date: July 31, 2007
project: WAYNFLETE ARTS CENTER, PHASE TWO, 2003-0040
re: Planning Board Public Hearing material
to: Shukria Wiar, Planner City of Portland
Anne Hagstrom Waynflete
from: Austin Smith Scott Simons Architects (SSA)

MEMORANDUM Site Plan Memorandum

MEMORANDUM Site Plan Punchlist Memorandum

date: July 3, 2007
project: WAYNFLETE ARTS CENTER, PHASE TWO, 2003-0040
re: Major Development, Site Plan Punchlist questions of May 31, 2007
to: Shukria Wiar
 Planning Department City of Portland
from: Austin Smith Scott Simons Architects (SSA)
cc: Scott Simons SSA
 Charles Young SSA
 Anne Hagstrom Waynflete
 David Cimino Stroudwater

Figure G
Typical curb along Storer Street

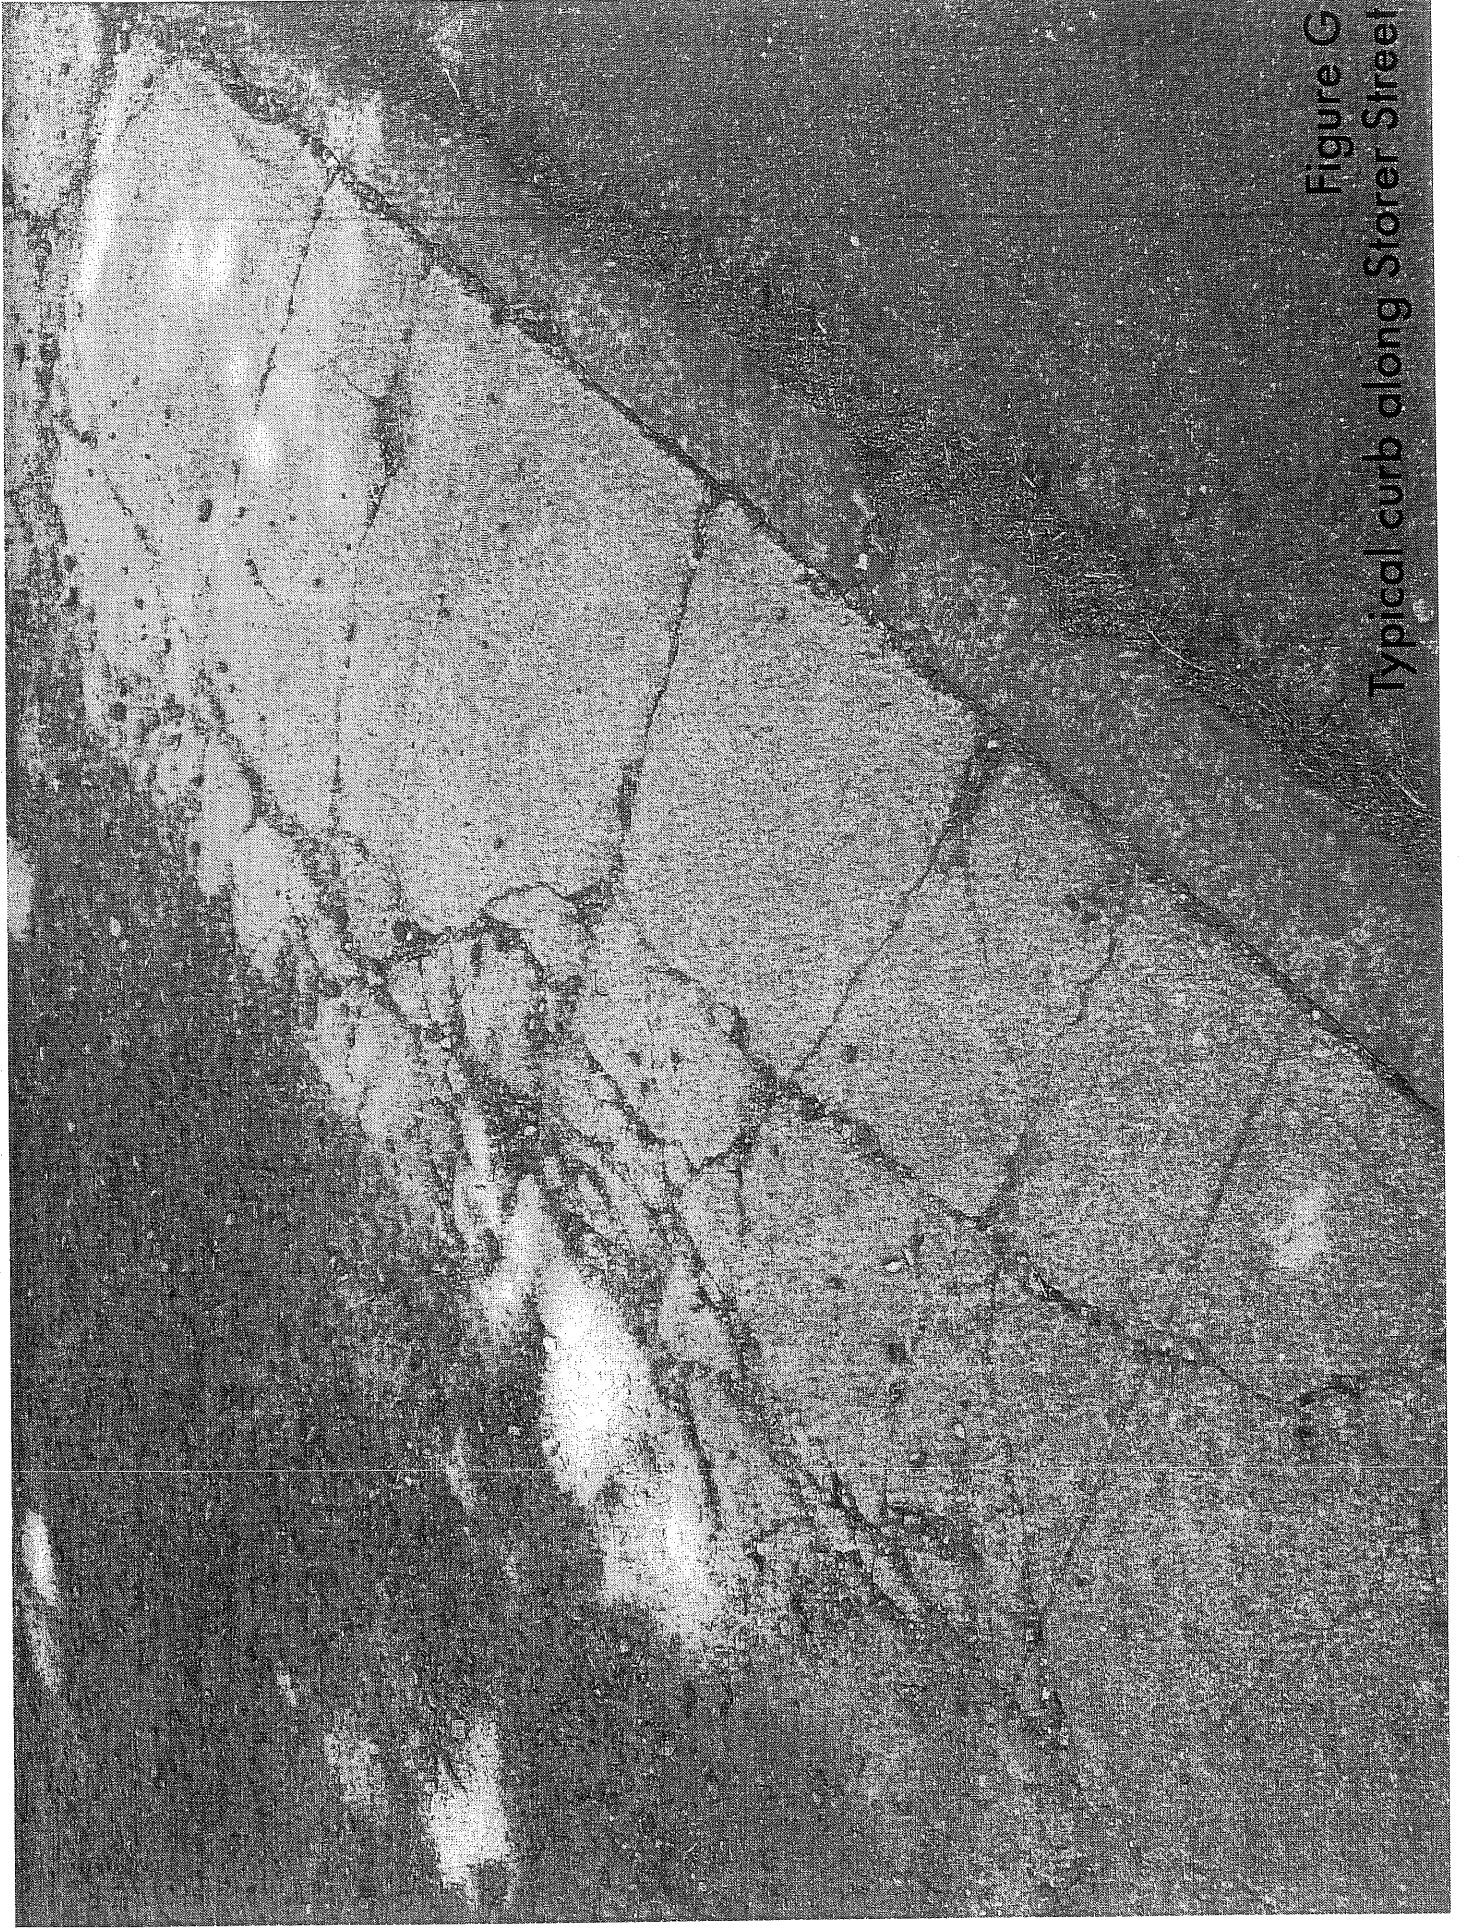
- d. *New Handicapped ramps should be constructed at the corner of Storer and Danforth Streets. The associated details will need to be included.*

- e. *The conditions of the existing sidewalk should be indicated.*

Concerning both items d. and e. please note the condition of Storer Street edge, curb and sidewalk in the enclosed photographs. In 2003 a new paving overlay was installed on Storer between Spring and Danforth Street. This raised the top of paving to within 1" to 1 ½" of top of curb. Without addressing the pavement elevation, it is difficult to reset curb heights for long term ADA compliance.

Existing sidewalk of the west side of Storer Street is cast in place concrete with granite curbing. See enclosed photographs of existing site conditions including Storer Street curbing / sidewalk , existing Norway Maple tree and Danforth Street sidewalk, stone retaining wall, plantings, and fencing.
